ACADEMY VILLAGE FILING NO. 3	GRADING & EROSION CONTROL PLAN	SHEET 2 OF 3	JOB NO. 25123.00
		DESIGNED BY AUH	CHECKED BY AUH
H-SCALE 1"=40'	V-SCALE 1"=X'	DATE 6/15/17	BY DATE
No. REVISION	RAB	RAB	DATE
UNTIL SUCH TIME AS THESE DRAWINGS ARE APPROVED BY THE APPROPRIATE REVIEWING AGENCIES, JR ENGINEERING APPROVES THEIR USES DESIGNATED BY WRITTEN AUTHORIZATION. PREPARED FOR RON COVINGTON HOMES 13725 STRUTHERS ROAD, SUITE 200 COLORADO SPRINGS, CO 80920 RON COVINGTON 719-491-1220 RCOVINGTON@COVINGTONHOME.COM			
J.R. ENGINEERING A Western Company Centennial 303-740-9888 • Colorado Springs 719-583-2583 Fort Collins 970-491-9888 • www.jrengineering.com

Markup Summary

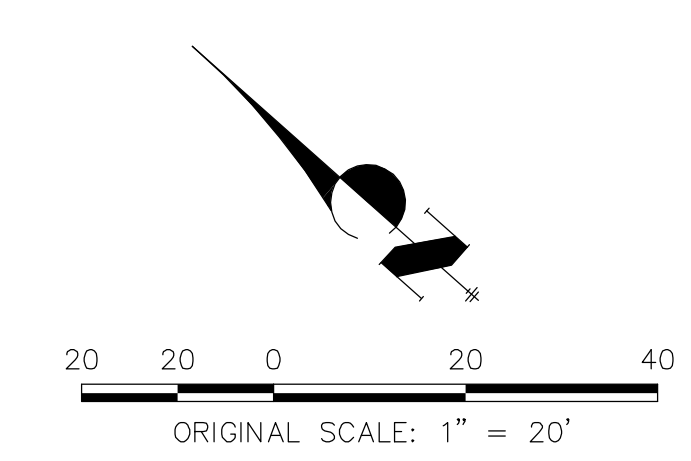
revise leaders to the correct location

Provide sheets 1 and 3.
